6 November 2013

***Modification Request for the University of Sydney Abercrombie Precinct
Redevelopment: Application Number: MP07_0158 MOD 3***

Ground Floor Plan
1:200@A1
11.10.13
4001_DA02-D

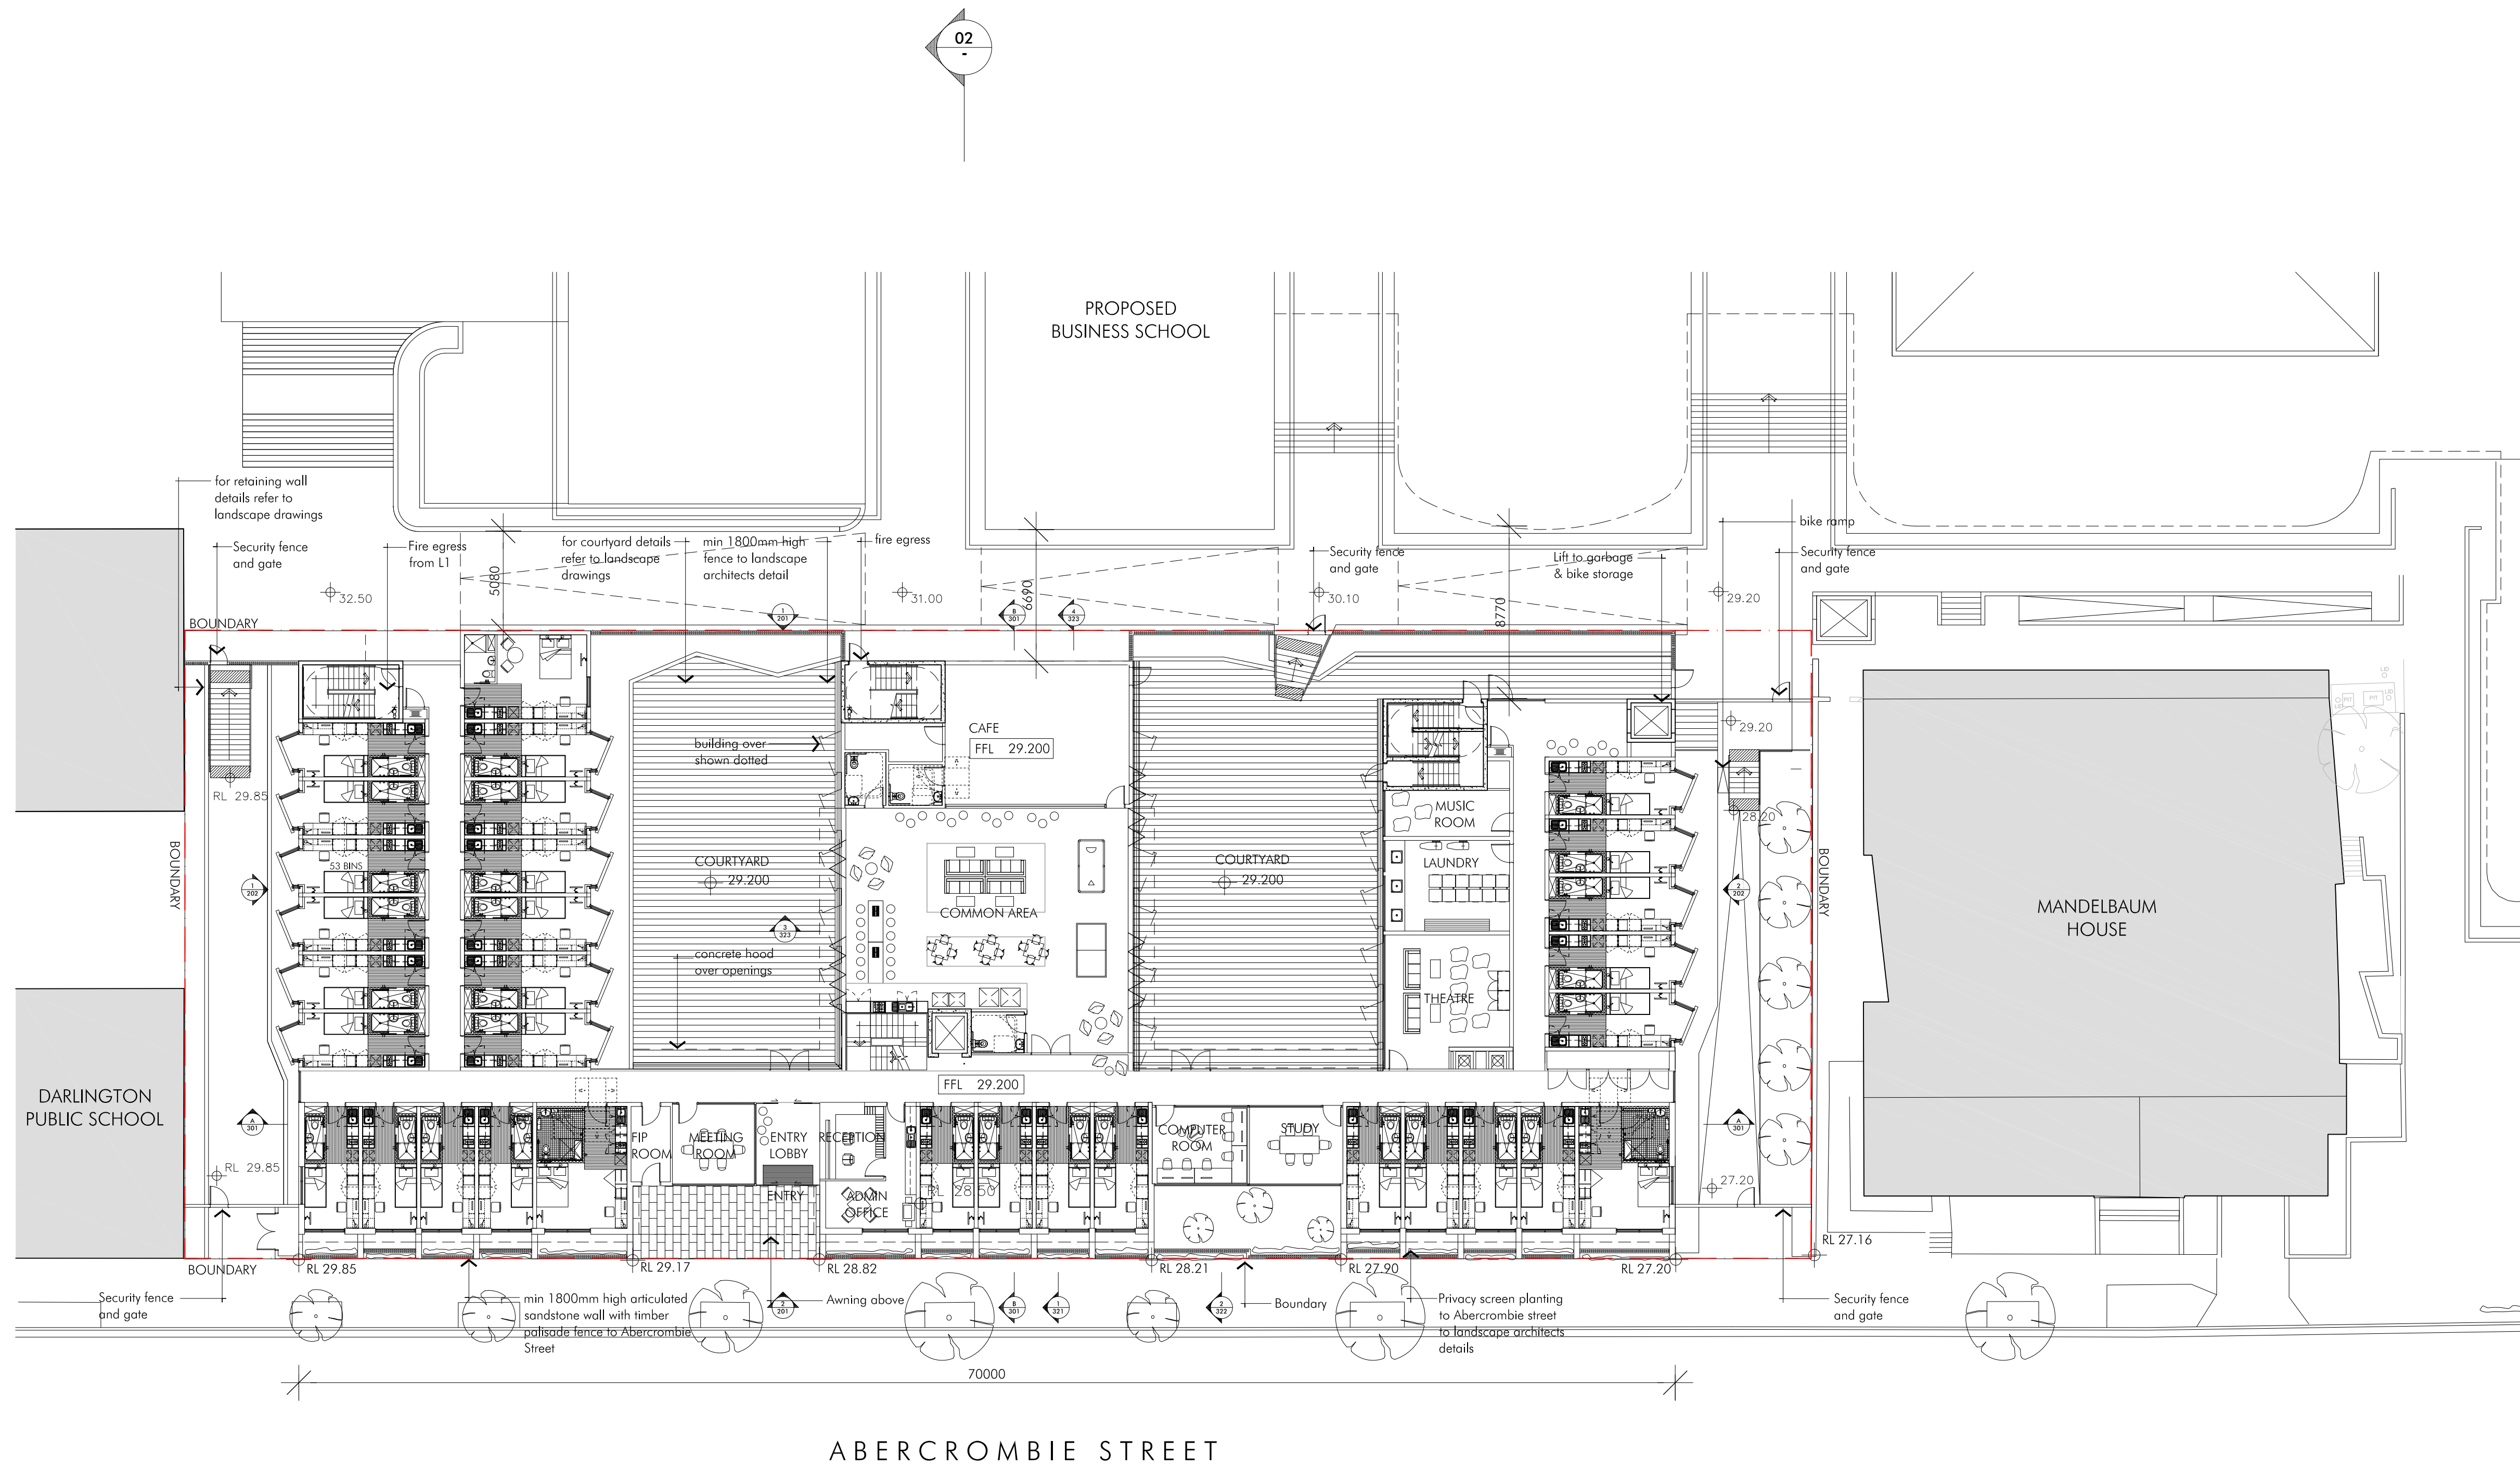
- The front of the Student Accommodation building should be built 2 metres back from the Abercrombie Street boundary. It should be set back from this boundary so that it is in line with Mandelbaum House as it was originally planned and presented to the community. The footprint of the buildings currently on the site, The Shepherd Centre and Boundary Lane Children's Centre, were built approximately 2 metres back from the Abercrombie Street boundary and align with Mandelbaum house. Therefore, the front footprint of the proposed Student Accommodation building should be the same as those buildings occupying the site at present and not be built up to the Abercrombie street boundary.

1 SECTION A
SCALE 1:100 @ A1

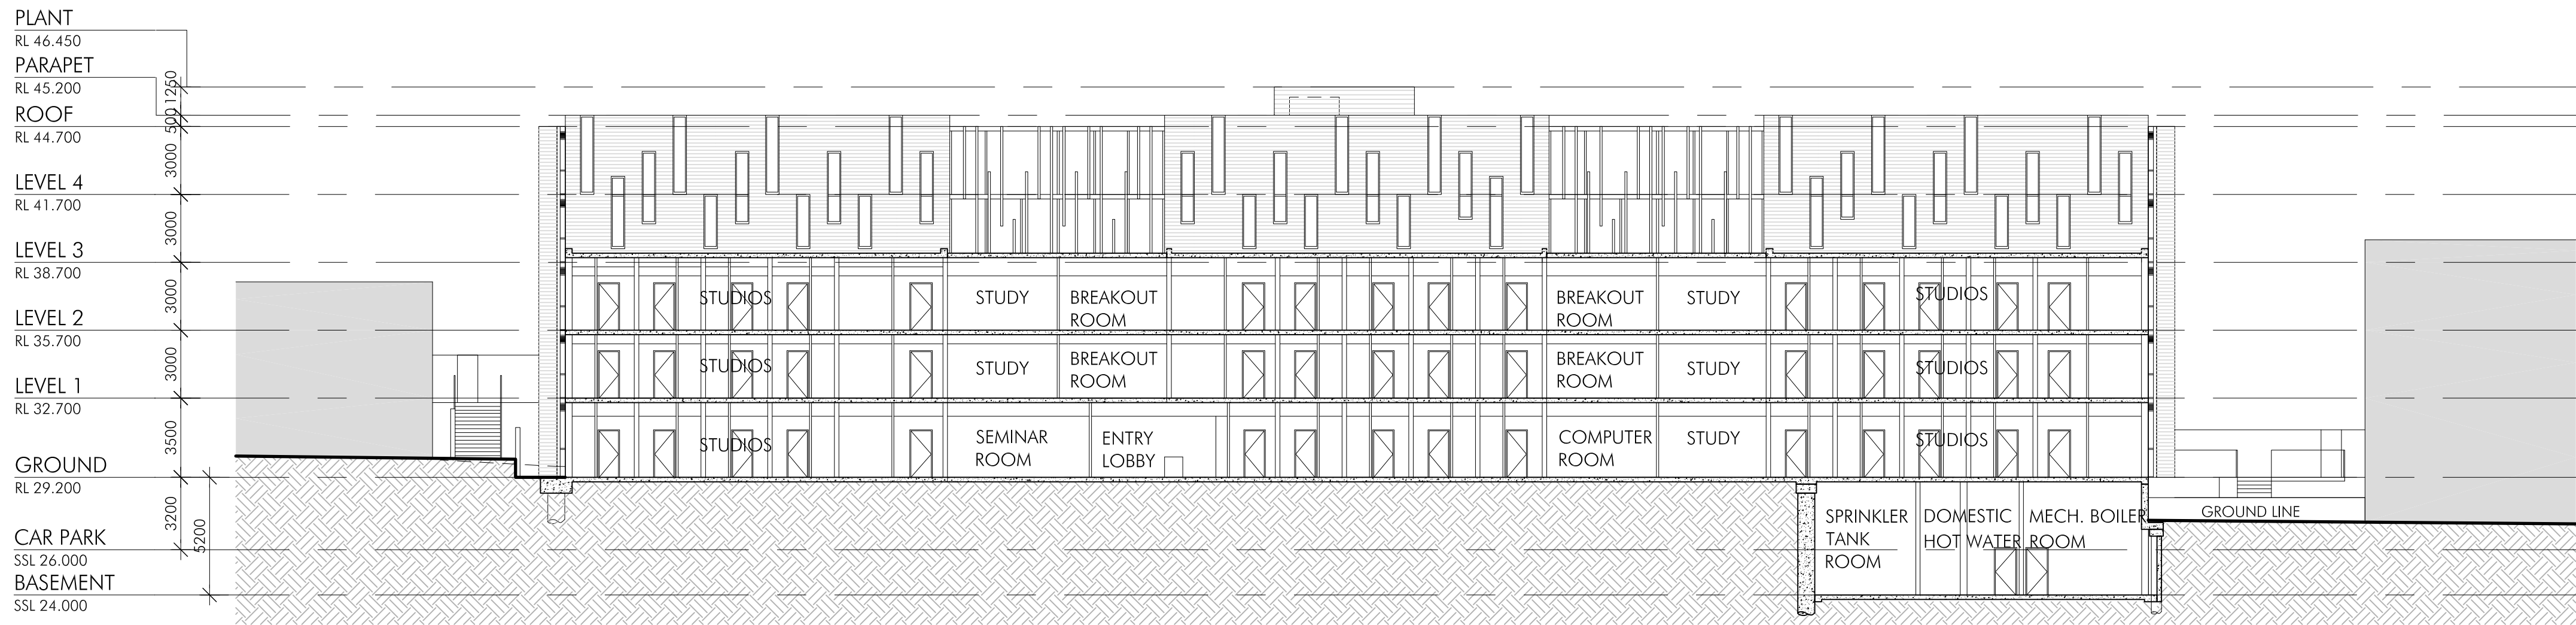
- The facade of the proposed Student Accommodation building does not reflect the heritage appearance of the Victorian terraces on Abercrombie Street as Mandelbaum House does. Therefore, it should be set back to allow for extensive vegetation and trees to be planted in front of the building on Abercrombie Street to help preserve the heritage streetscape and improve both the aesthetics and the environment of the street.
